The Sizewell C Project

9.10.27 Initial Statement of Common Ground - Minsmere Levels Stakeholder Group

Revision: 1.0
Applicable Regulation: Regulation 5(2)(q)
PINS Reference Number: EN010012

June 2021

REVISION:
03

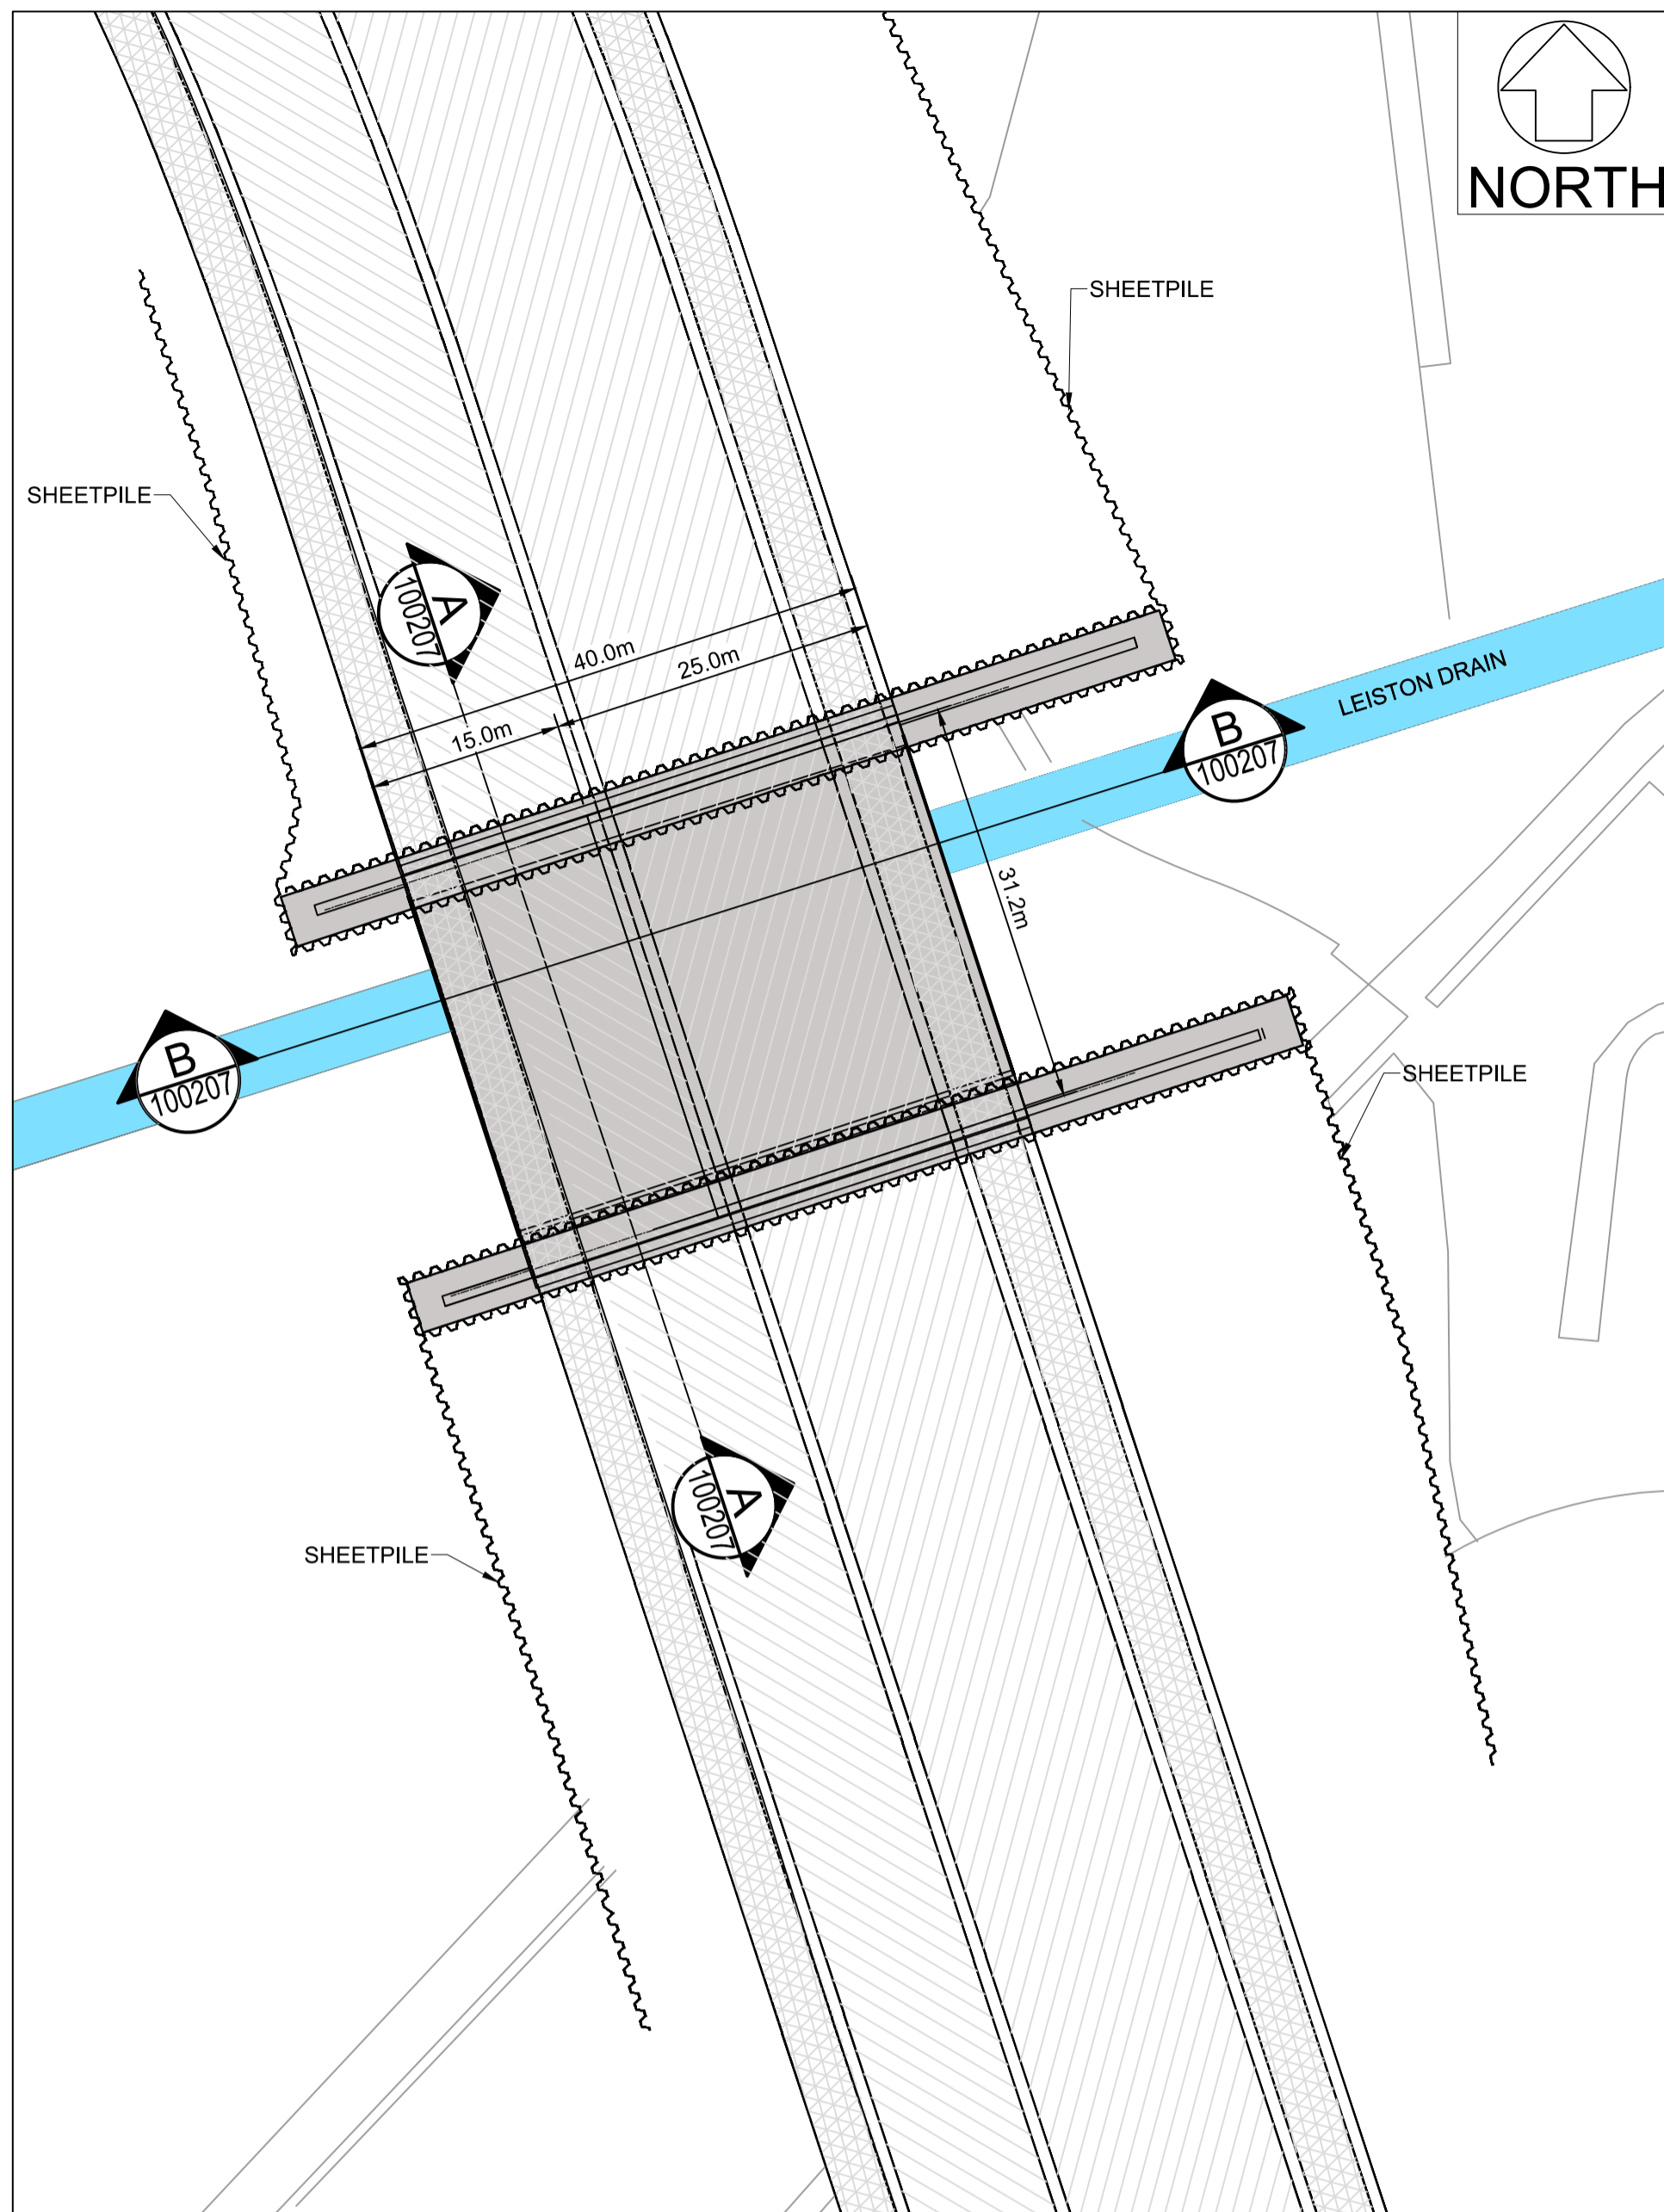
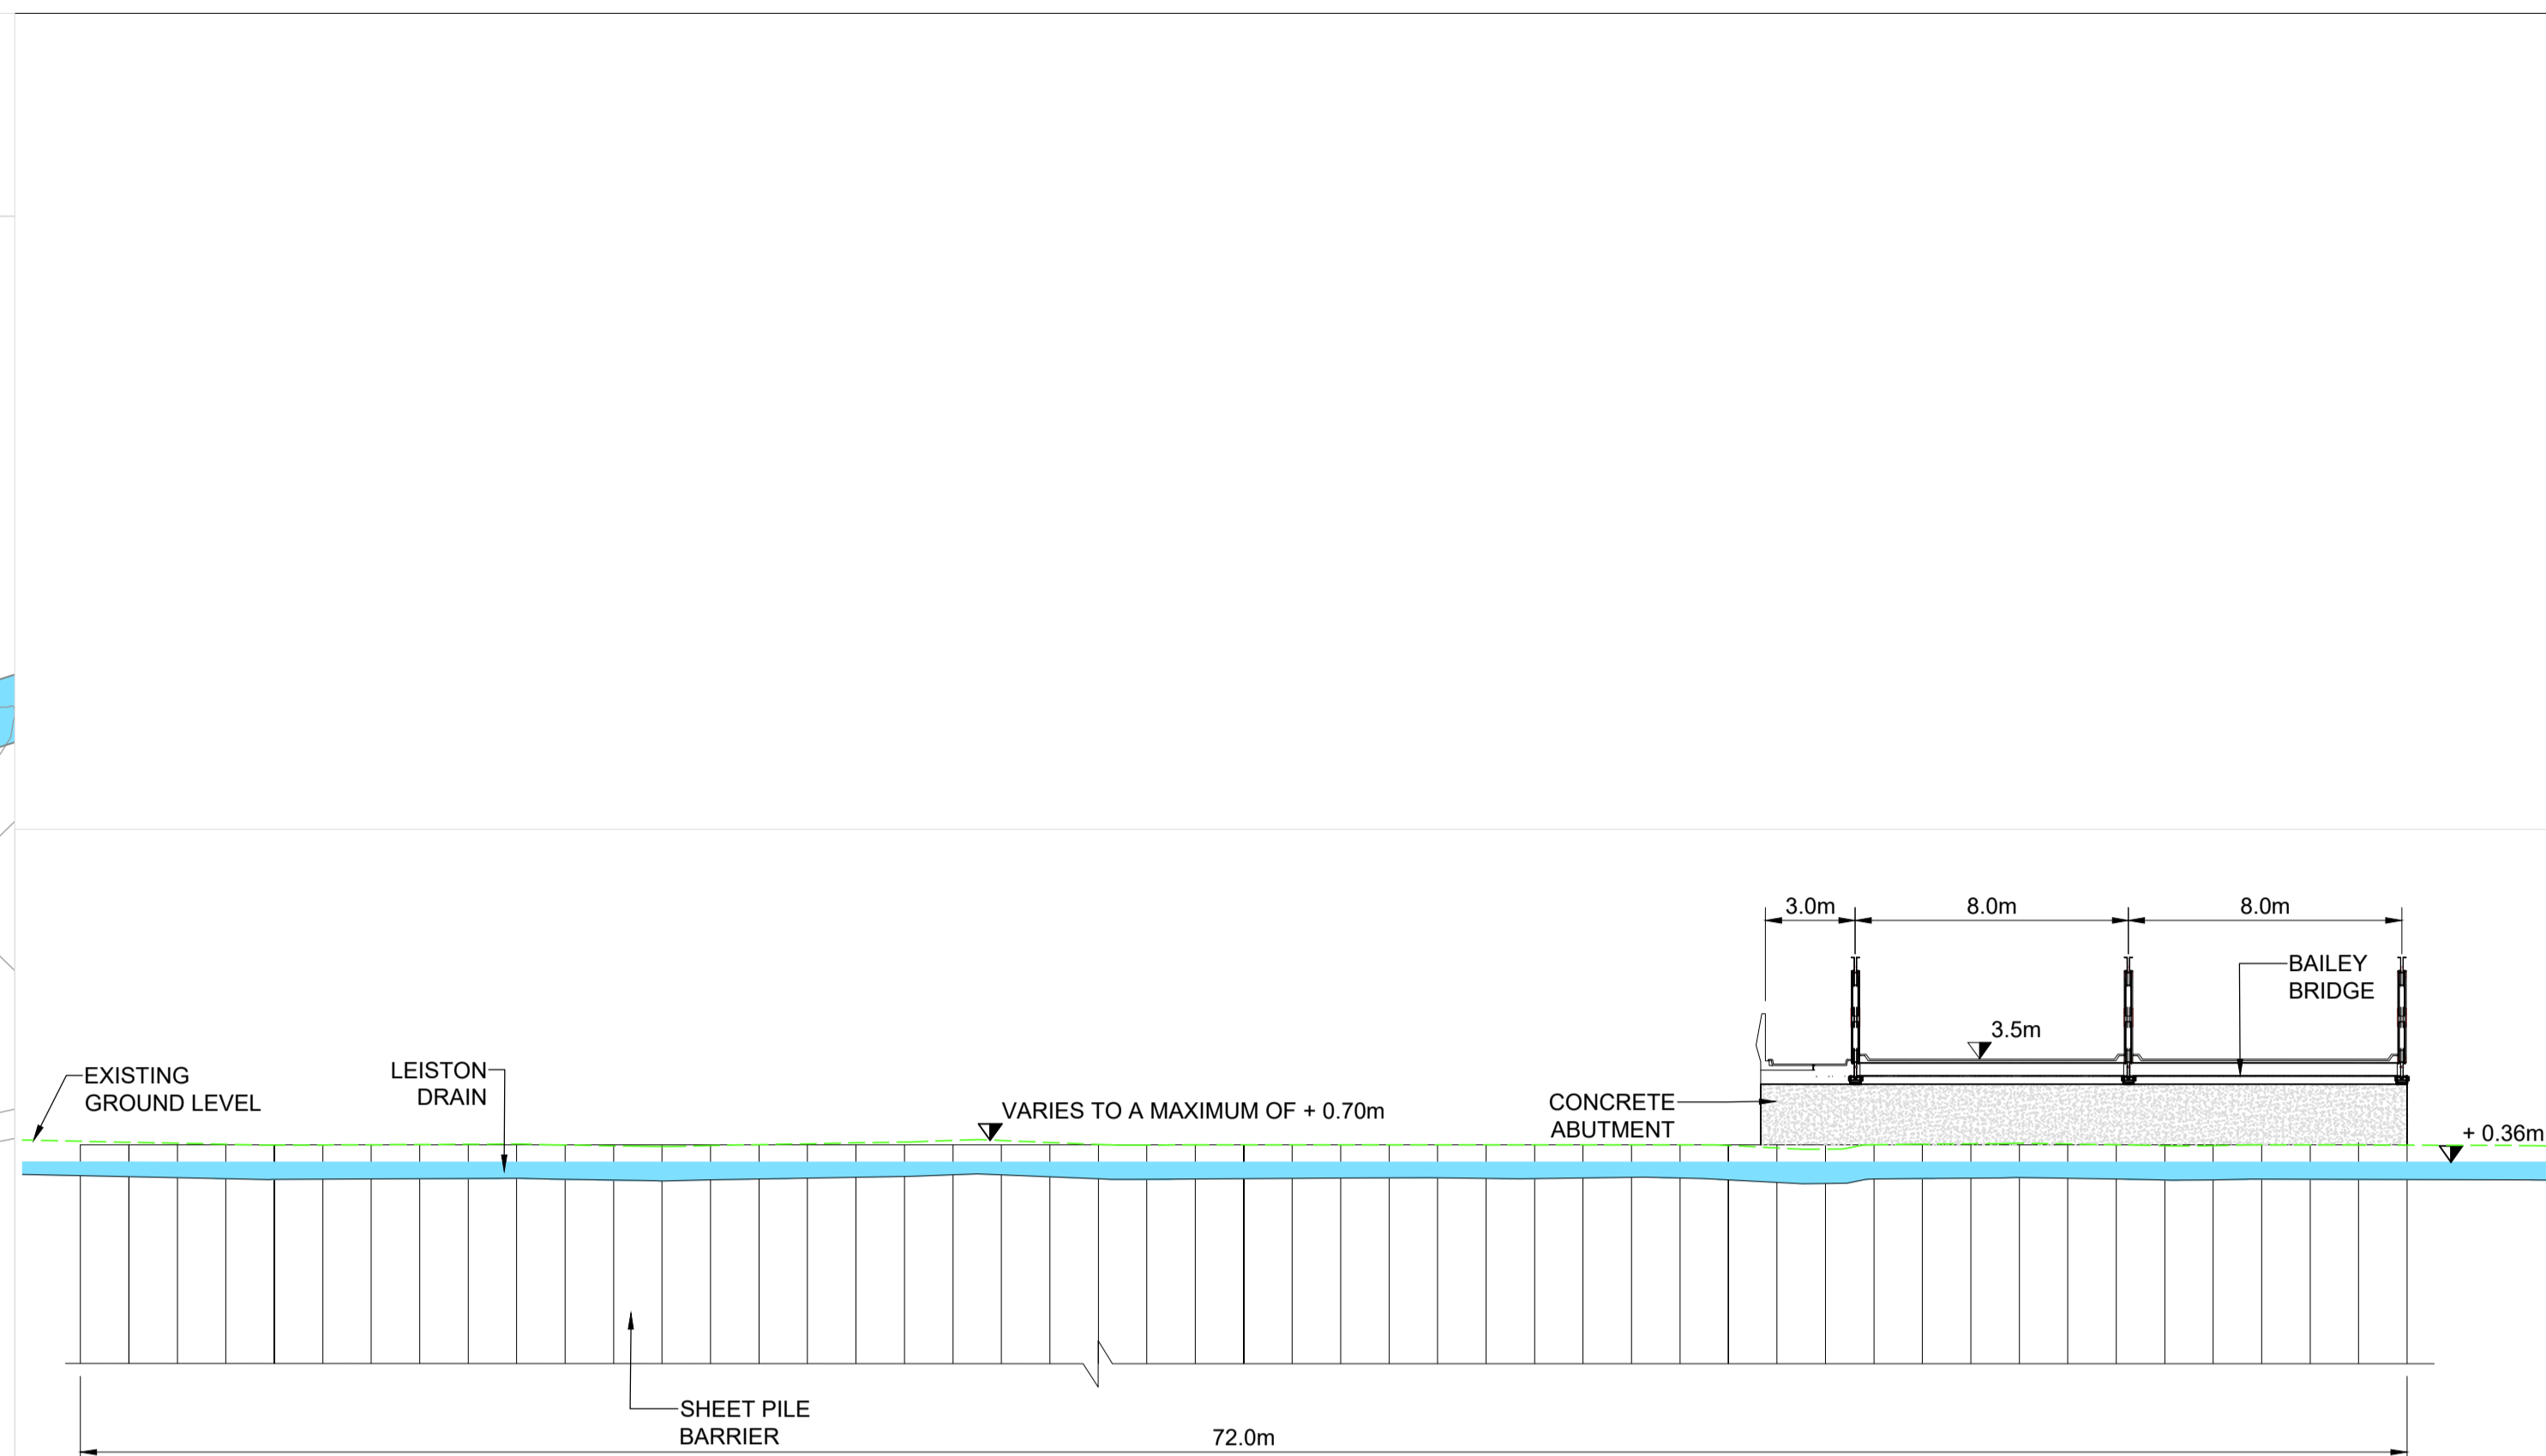
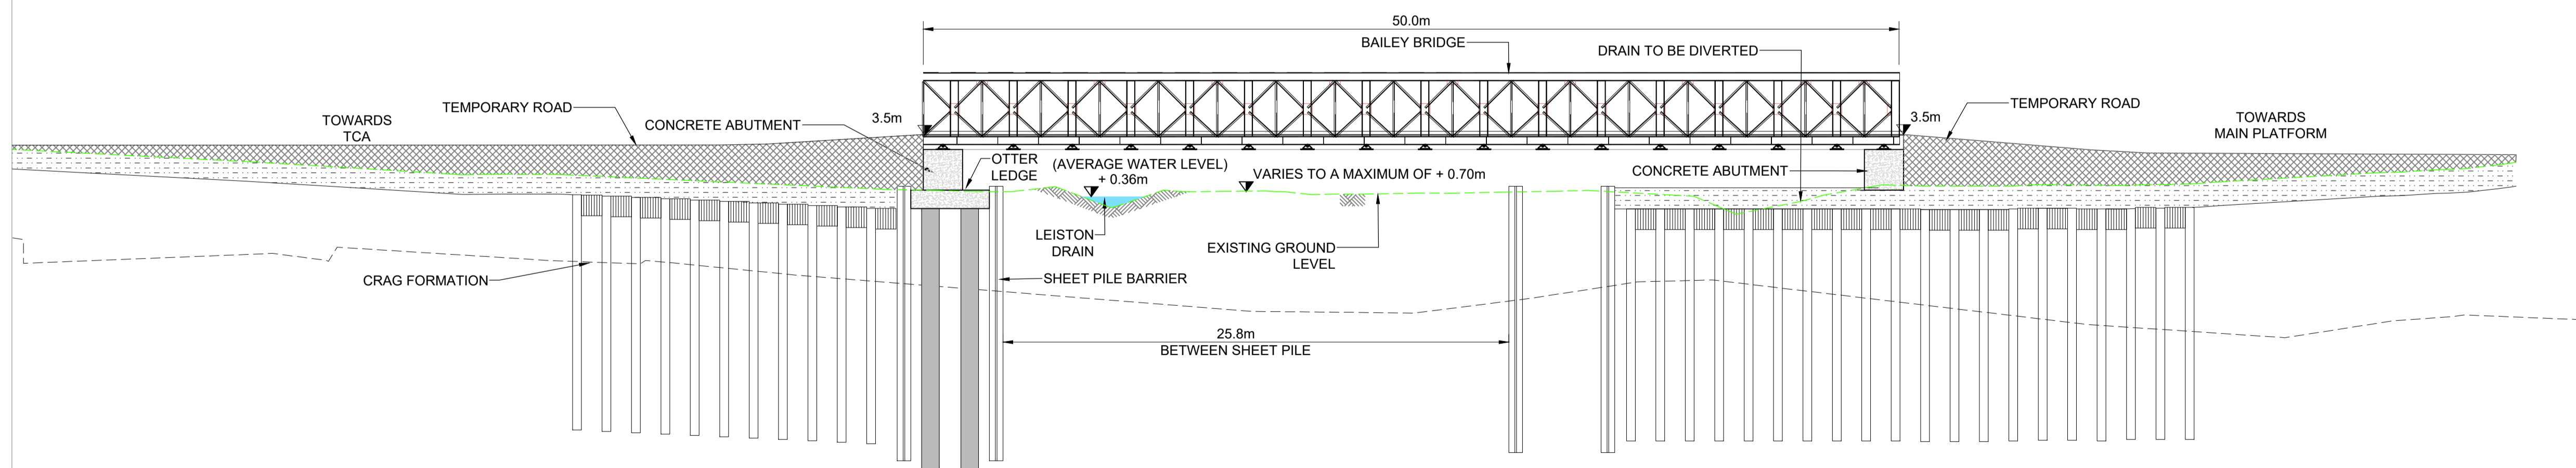
7	Impact of the SSSI Crossing	<p>RR: Hydrological impacts of the proposed Causeway and Culvert crossing are not properly assessed.</p> <p>The overall ecology of both Sizewell Marsh and Minsmere Levels are reliant on the annual cycle of ground and surface water changes, any disturbance will have direct impacts on bird, insect, reptile and mammal species.</p> <p>At 7th May: MLSG support the position of SCFOE, Suffolk Wildlife Trust (SWT) and RSPB as stated in the position of the parties.</p> <p>We support Environment Agency's (EA) position that the wider culvert proposal, now accepted in the changes to the DCO, still do not meet the need for an open construction, as proposed in earlier consultation options for a 3 span bridge structure and are concerned that long dark culvert will not satisfy the Water Framework Directive. Any significantly piled structure placed across the narrow gap between Sizewell Marsh and Minsmere Levels will have an impact on both ground and surface water quality and flows and we concur with EA and SCFOE that the structure as proposed is unacceptable.</p> <p>The proposals to replace coastal fenland with fen meadow only is misplaced because the habitats being destroyed are a matrix of other habitat types that together also enable the exceptional SSSI special interest feature (invertebrates) to exist. This appears to have been overlooked. All proposed sites for fen</p>	<p>The original design of the SSSI Crossing culvert had been oversized to minimize effects on natural hydrologic function. However, flood risk modelling showed that during extreme events the culvert could impede the flow of flood waters, albeit with very small effects on flood levels. The proposed widened bridge design further limits the impact on hydrology, and also on flood flows. Consequently, the impact of flood levels is further reduced and the effect from the revised SSSI Crossing is substantially mitigated, both for the development and off-site receptors.</p> <p>Further details are set out in the ES Addendum (Doc Ref 6.14), Main Development Site Flood Risk Assessment Addendum (Doc Ref. 5.2(A)Ad) and Outline Drainage Strategy (Doc Ref. 6.3) [APP-181].</p> <p>As noted above, the degree of change in water level is not expected to have significant adverse effect on the habitats within the Sizewell Marshes SSSI.</p> <p>Sizewell Drain would be diverted north, parallel to the base of the platform slope, provided in Appendix 19C of the ES. At its northern extent, it would discharge to the Leiston Drain upstream of the SSSI crossing. In addition, revised water level management may be required for the drainage units and watercourses adjacent to the construction site. This would require the inclusion of a water level control structure along the realigned Sizewell Drain. This structure would allow for fine tuning of water levels. The control structure will act to prevent any detrimental impacts on groundwater from the Sizewell Drain. The specific position, nature and operational parameters of the control structure will be determined in conjunction with</p>	<p>SZC's Position</p> <p>Not agreed. However, a meeting can be arranged by the Applicant to discuss opportunities for narrowing the area of disagreement between us on this topic.</p> <p>MLSG's Position.</p> <p>Not agreed. Whilst a meeting has been offered, at this time we decided to respond electronically and may request a meeting at a future date.</p>

Ref.	Matter	MLSG's position [Starting from relevant representation (RR)]	SZC Co.'s Position	Position of the parties
			single span bridge design to identify opportunities to further reduce impacts on the SSSI. This work is ongoing but we are confident that at the end of construction the width of the single span bridge can be reduced from 40m to approximately 15m. It will also be possible to increase the soffit level although the design review has not yet concluded in this respect. Details of the optimised design are to be provided at Deadline 4.
